Subject: RE: URGENT FW: Planning Consultation on: BN/126/21/DOC - Tile Barn Farm - RE CONSULTATION REQUEST

Engineers Comments Regarding Surface Water Drainage

Application No: BN/126/21/DOC
Registered: 27th September 2021
Site Address: Tile Barn Farm 32 Hill Lane Barnham PO22 0BL
Description of Works: Approval of details reserved by condition imposed under ref W/4001228 (BN/24/20/PL) relating to Condition Nos 3 - materials and finishes, 5 - noise, 6 - dustbin enclosure, 7 - renewable energy, 10 - covered & secure cycle parking, 11 - electric vehicle charging, 12 - surface water drainage and 13 - foul drainage.

G6445-02

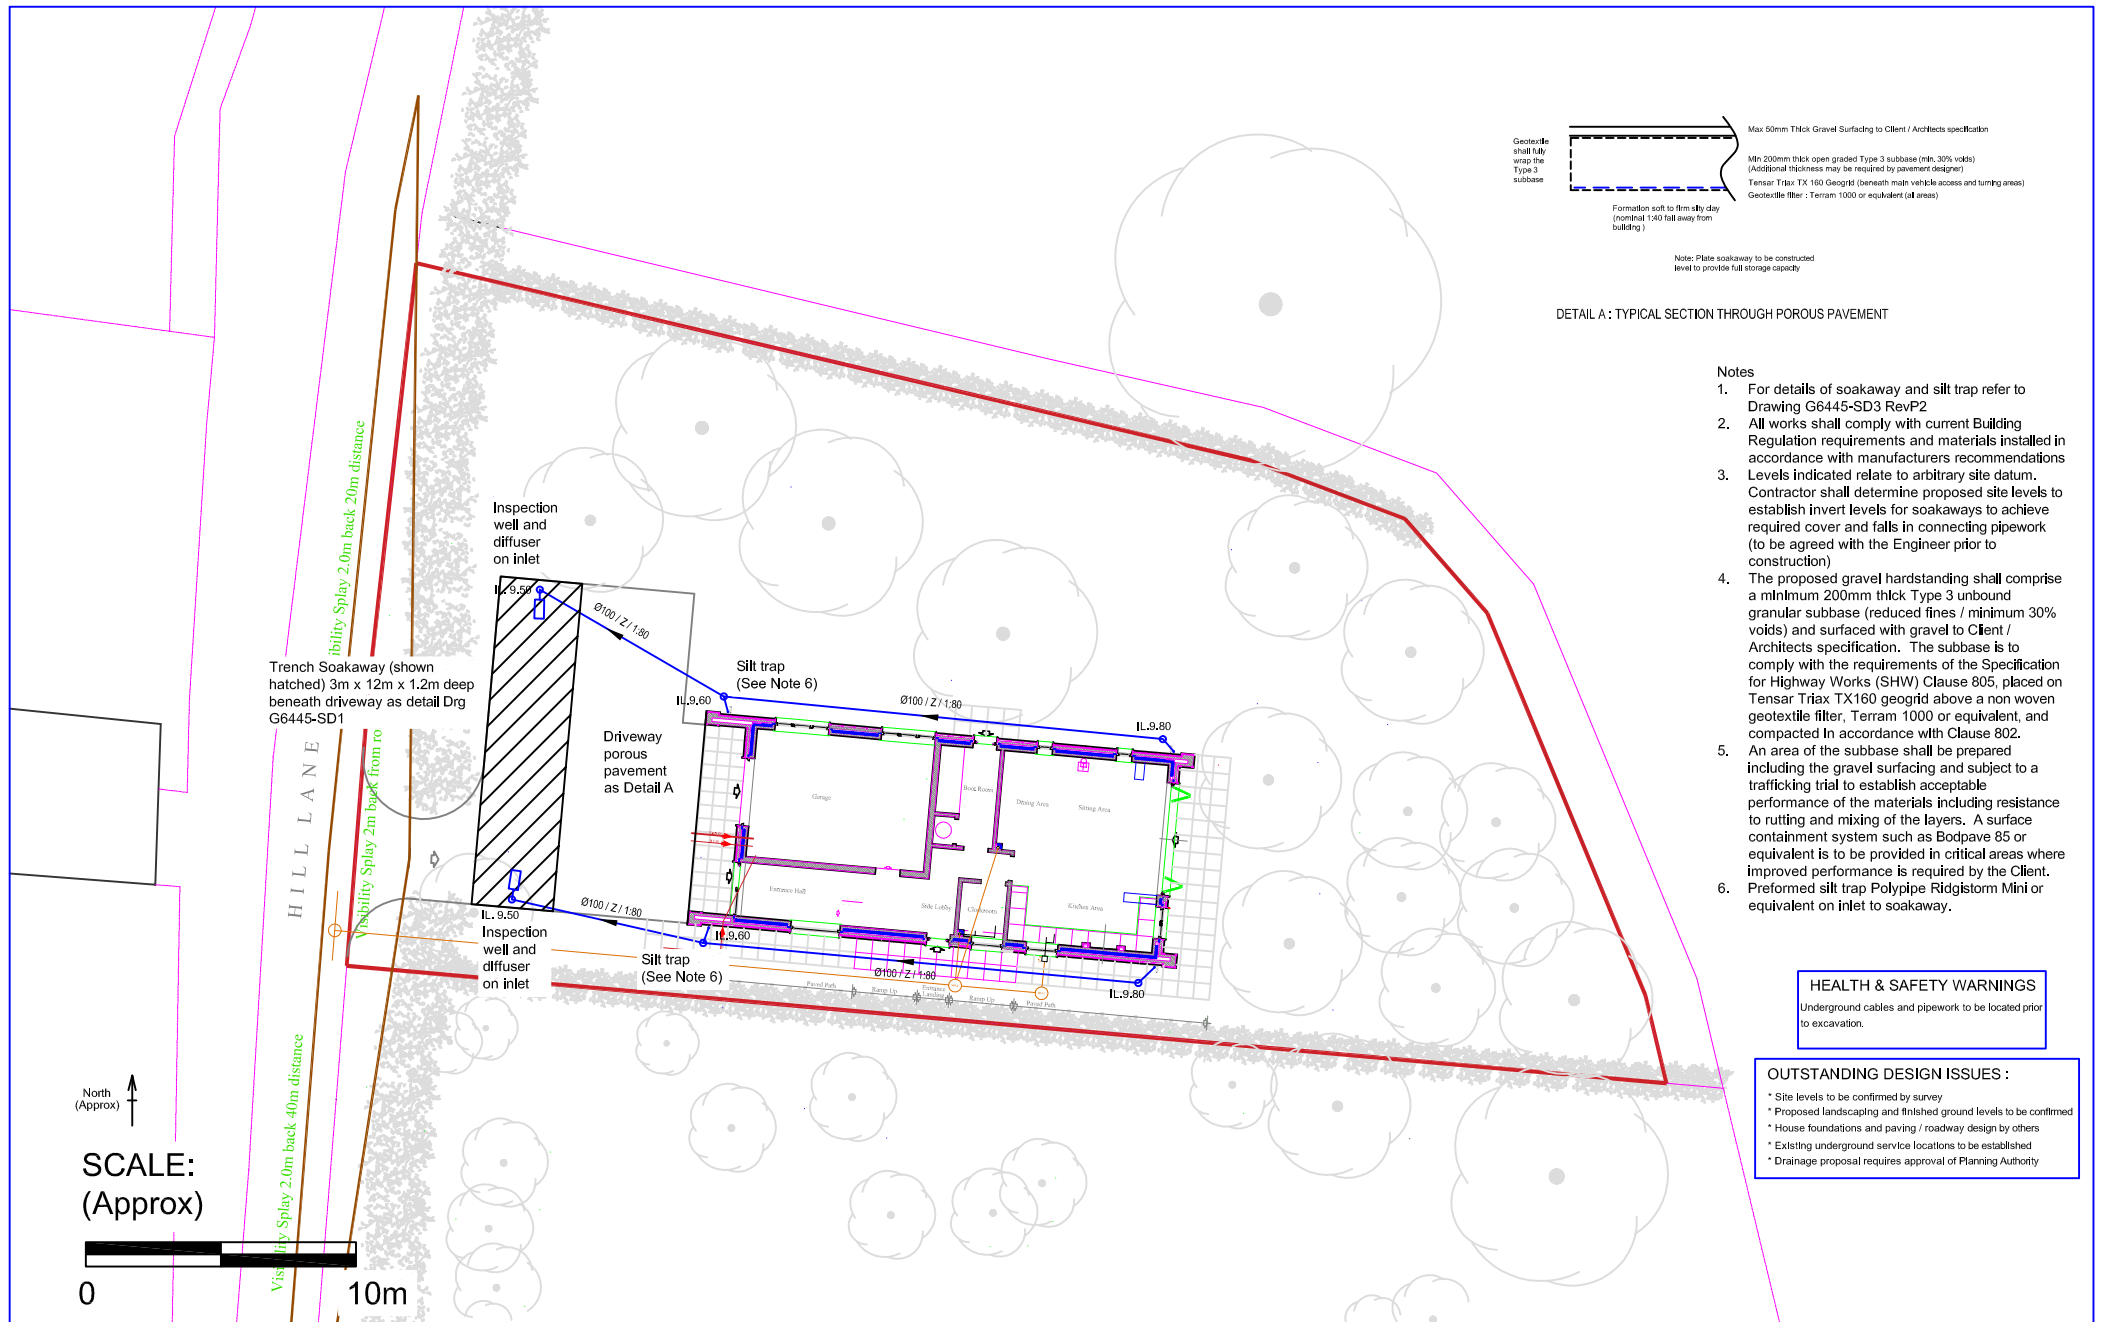
The drainage layout shows preformed silt traps (Polypipe Ridgistorm Mini or equivalent), and yet the catchpit detail shows an alternative to a pre-formed silt trap. Please show the pre-formed silt trap on the construction detail or change Note 6 to be a bespoke silt trap as shown on the construction details. Please also include sump depths, cover types and cover levels on the drainage layout.

- Drainage Layout G6445-02 Rev P3
- Drainage Details G6445-SC3 Rev P4
- Drainage Details G6445-SD1 Rev P2

SILT TRAP DETAIL
(alternative to preformed trap)

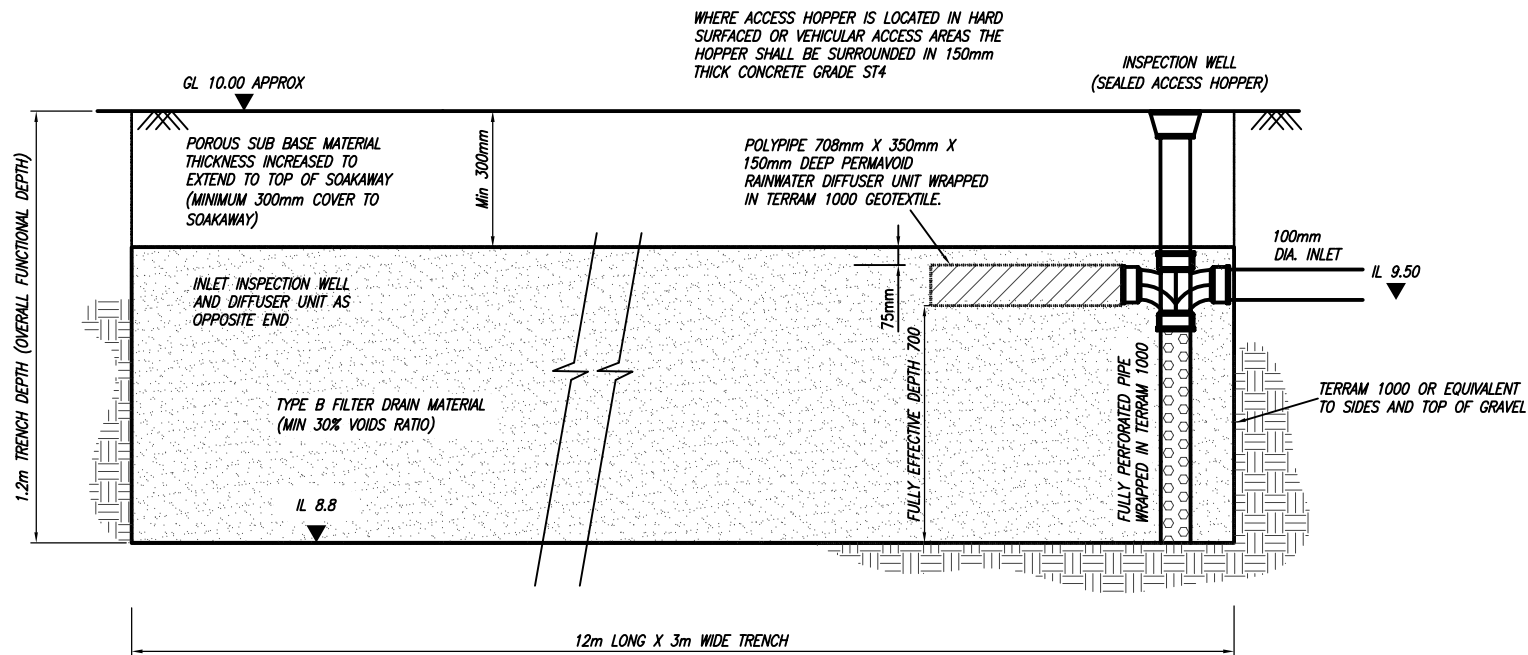
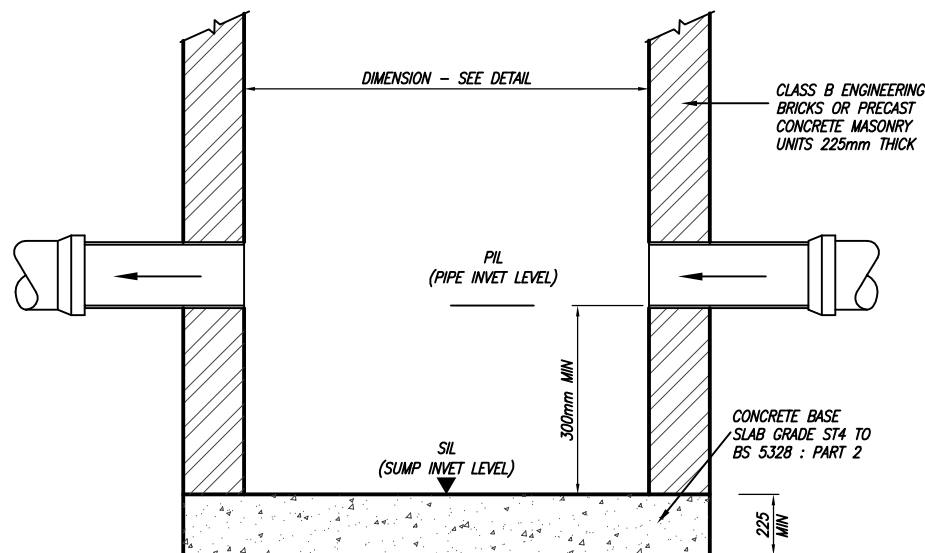
The calculations that have been provided illustrate only the invert level of the soakaway (8.8m) and the ground (cover) level (10m). I am concerned that they assume the depth of the soakaway to be 1.2m rather than the effective depth of 0.7m. Please can the applicant clarify these inputs so that I can be sure that the soakaway drawn is what is modelled.

Please specify no fines in the granular fill of the soakaway.
